RE: TO ABP RELATING TO THE AMBASSADOR THEATRE, PARNELL STREET, DUBLIN 1, D01 R243: RESPONSE TO REQUEST BY AN BORD PLEANÁLA (ABP) TO MAKE A SUBMISSION IN RELATION TO DUBLIN CITY COUNCIL'S (DCC) SUBMISSION IN RESPONSE TO A SECTION 5 REFERRAL

Dublin City Council Reference: 0029/22
An Bord Pleanála Reference: 312927-22

Figure 2a. Coade Stone decorative frieze to the rotunda theatre showing Bucranium and roundel.

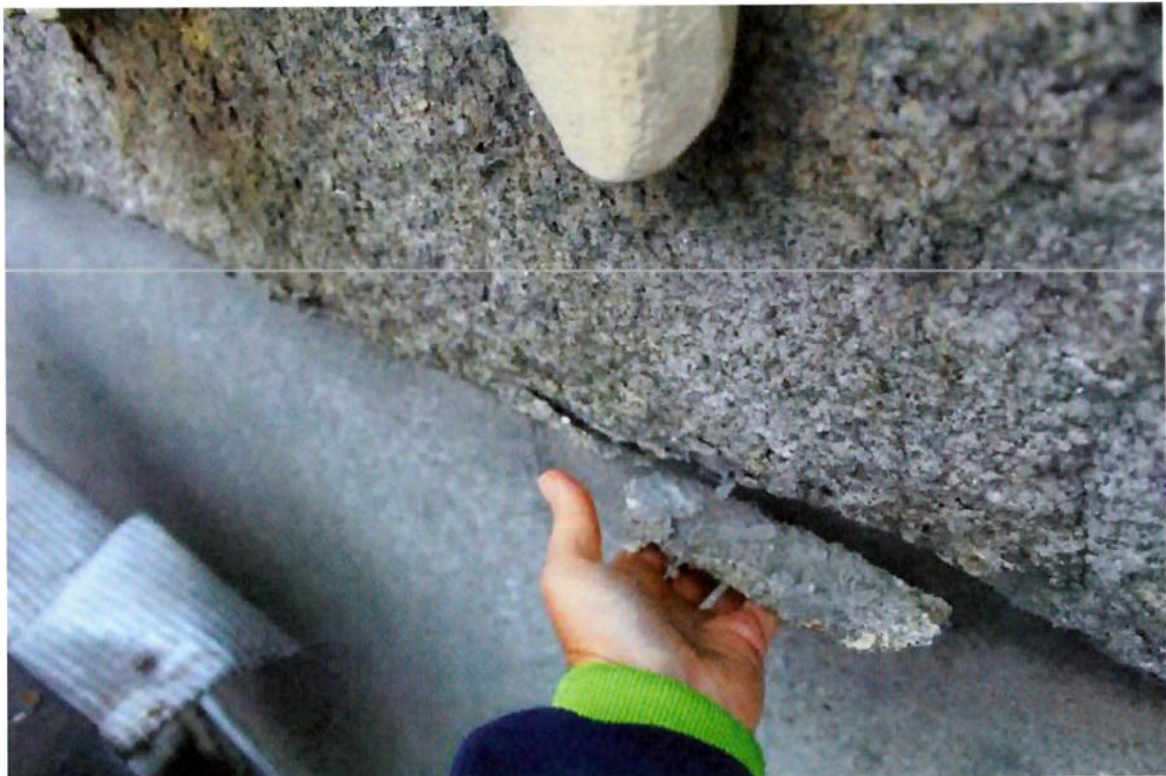
2. Coade Stone

- Details and methodologies of repair will be sought from a Coade Stone manufacturer, Stoneware Restoration Ltd or equal and approved.

Figure 12. Return wall to front elevation. Proposed works are repointing open joints, replace decaying render swags and gentle cleaning to lighten staining in the niche.

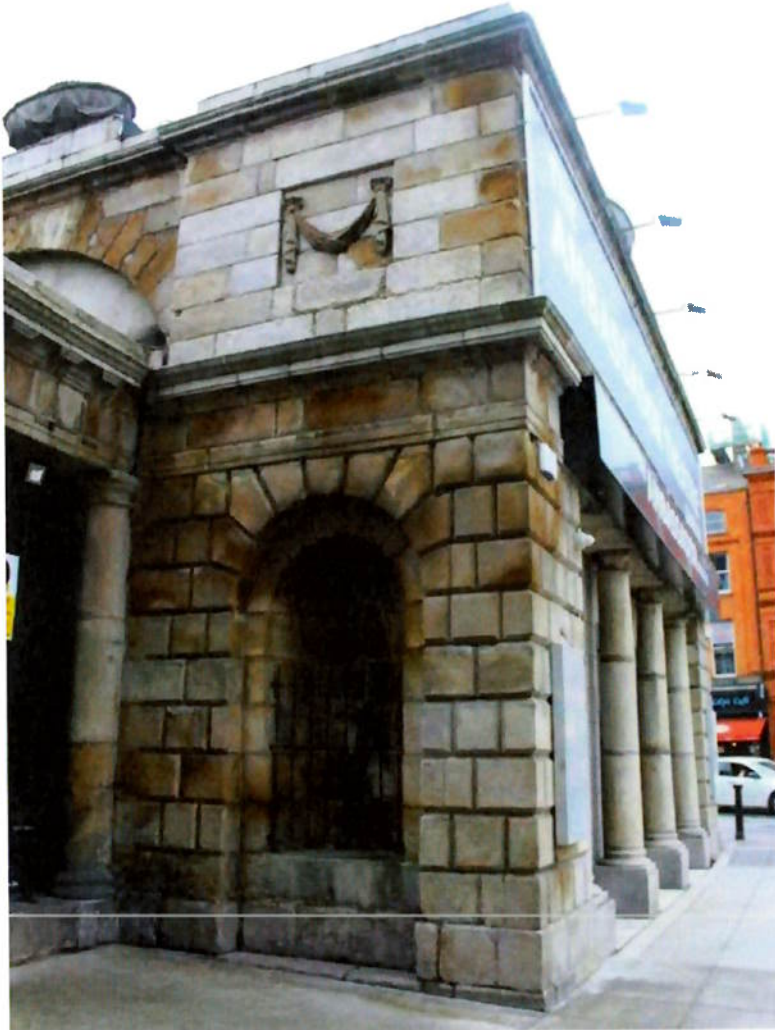
4. Render

- Samples of all repairs to mortar shall be approved before any work commences. It often takes several samples before the exact right mix is found.
- The rear elevation has a patchwork of finishes and repairs and in this case a shelter coat is proposed to unify the elevation. This does not harm the substrate and is sacrificial.

Figure 17 Cracks to the granite soffit. All soffit granite to be inspected by a conservation accredited engineer.

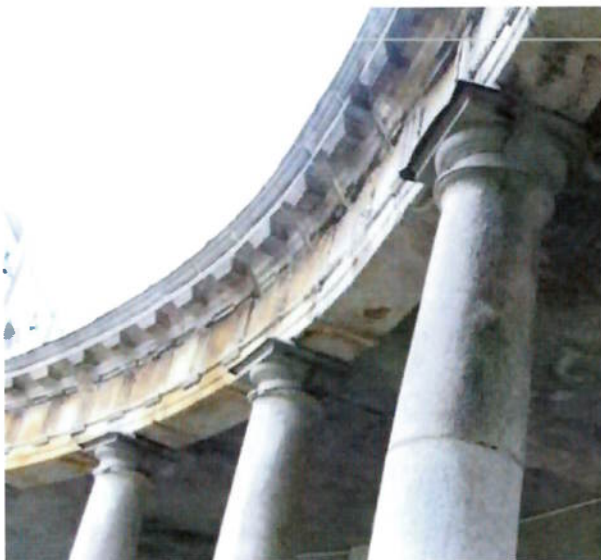
1. Cracking to the Granite Soffit

- The exact cause of cracking is unknown. It may be caused by rusting iron fixings, which have expanded and caused cracking. Further investigation is required.
- The client shall engage the services of a conservation structural engineer. He or she can investigate and make an assessment on what if any work is required. If specific opening up work or invasive work is required, then approval will be sought from Dublin City Council.
- An engineer will normally recommend tell-tales to be fixed to establish if the cracking is continuing or historic? A further assessment can be made after a period of time to see if further intervention is required. If not, the cracks will be filled and the area repaired.
